Please upload onto Ocella the email below which is a representation from a local resident to planning application
A/76/20/PL – Land at Dappers Lane, Angmering.

From: J Henderson [REDACTED]
Sent: 05 October 2020 18:14
To: Michael Eastham <Michael.Eastham@arun.gov.uk>
Cc: Paul Cann <Paul.Cann@arun.gov.uk>
Subject: A/76/20/PL

Drawing Title: Proposed Drainage Strategy

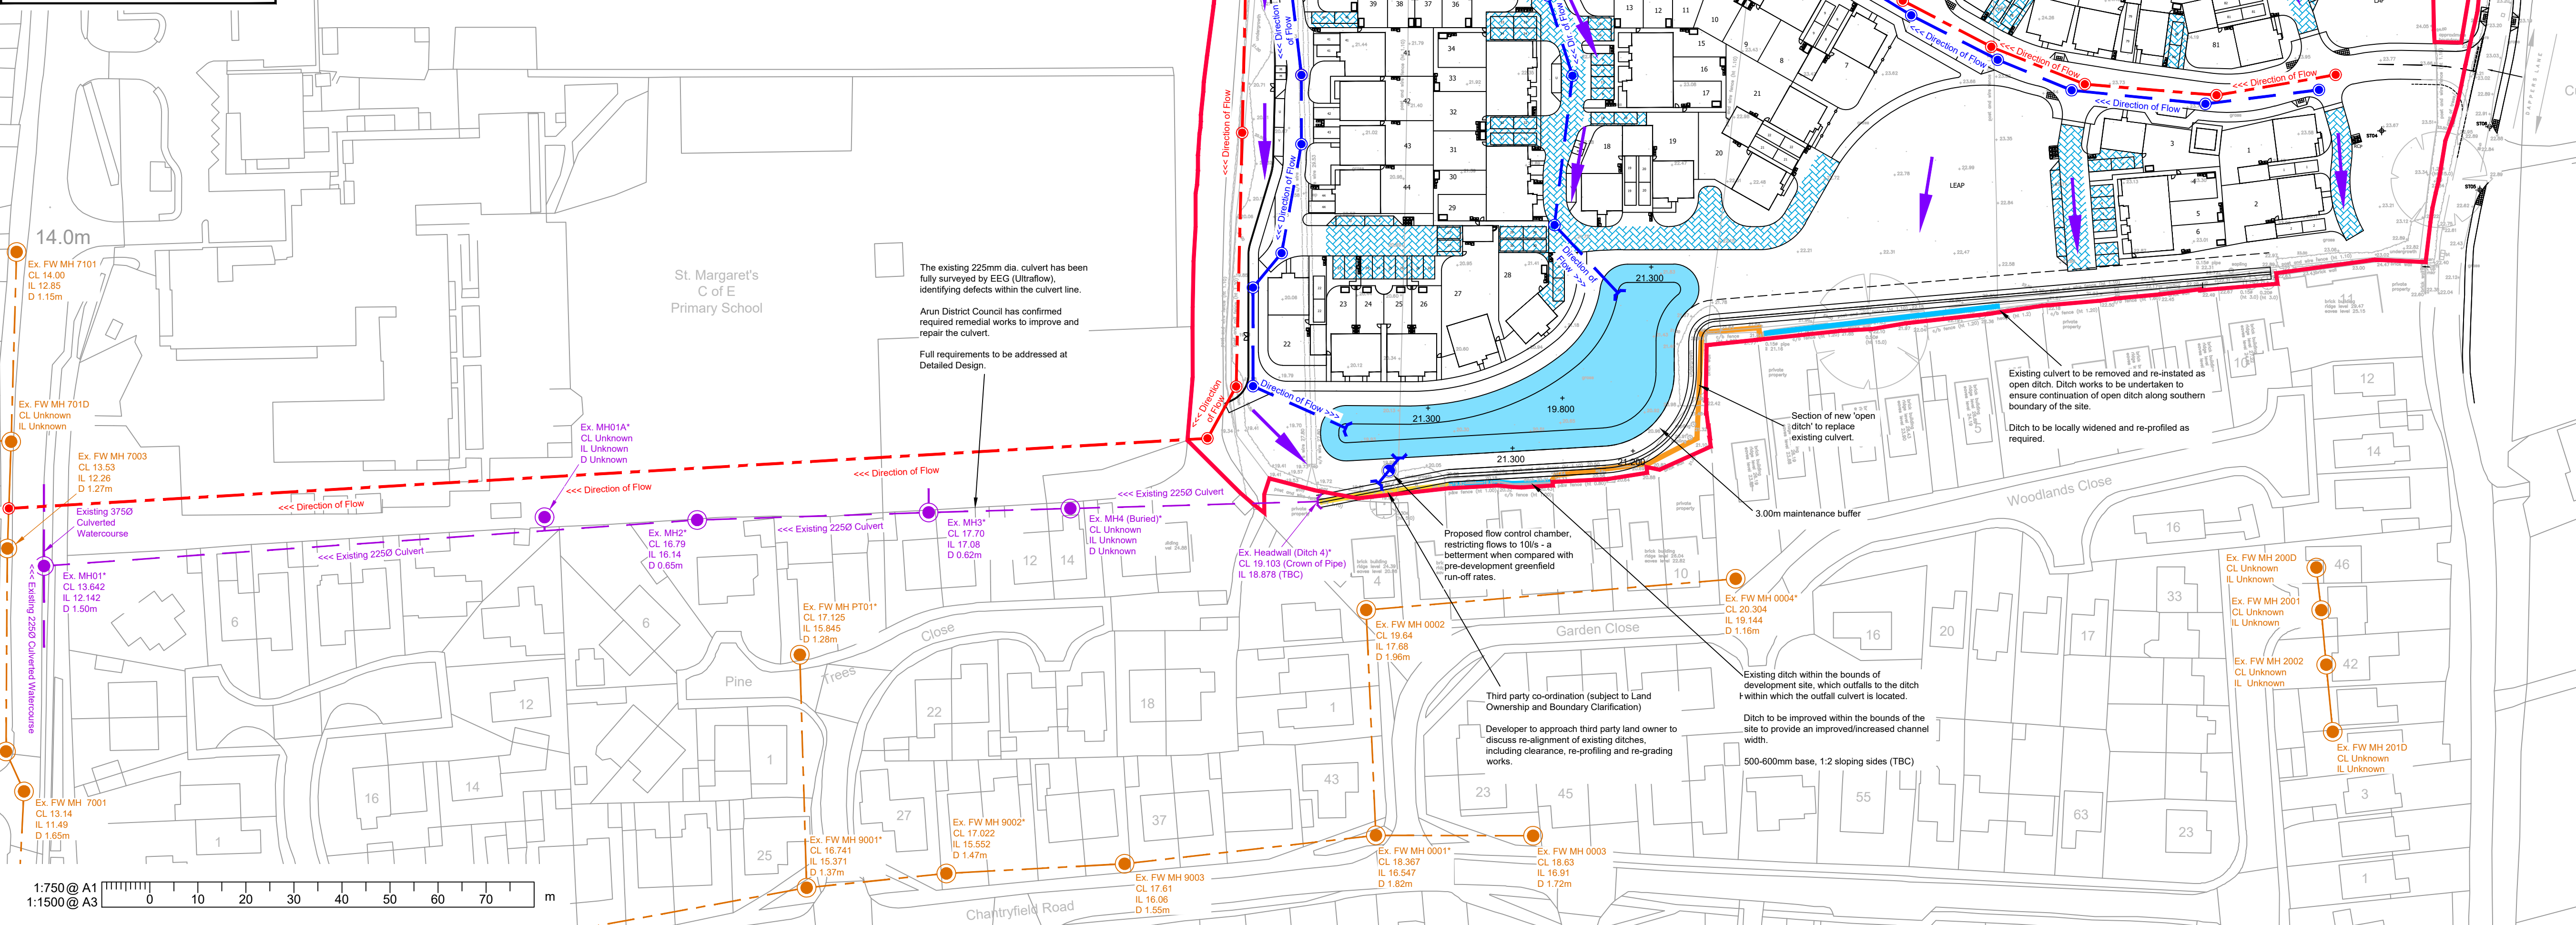
My original objection, which remains unchanged, that Dappers Lane is not suitable for and is unable to cope with the increase in traffic and widening just 10% of the total length of it will not solve the problem of it's narrowness and blind bends, but to which I wish to add the question of the drainage problem to the site and what effect the construction of a full length foot path on the eastern side will have.

Please see the attached photograph of the culvert waterway alongside the Merry England development after just 24 hours of rain, this shows the water run off from a area of just 18 properties not 84 as planned.

I'm not qualified to comment on the design or calculations for the drainage systems but am concerned that they are not sufficient to cope, from experience of living in the area for over 40 years it has a history of flooding, the area is full of natural springs and underground streams. I therefore require the authorities, ADC, WSCC and Souther Water etc, to satisfy themselves that every aspect of the plans have been fully explored in great depth and detail rather than just accept figures that tick boxes, failure to do so could have serious consequences.
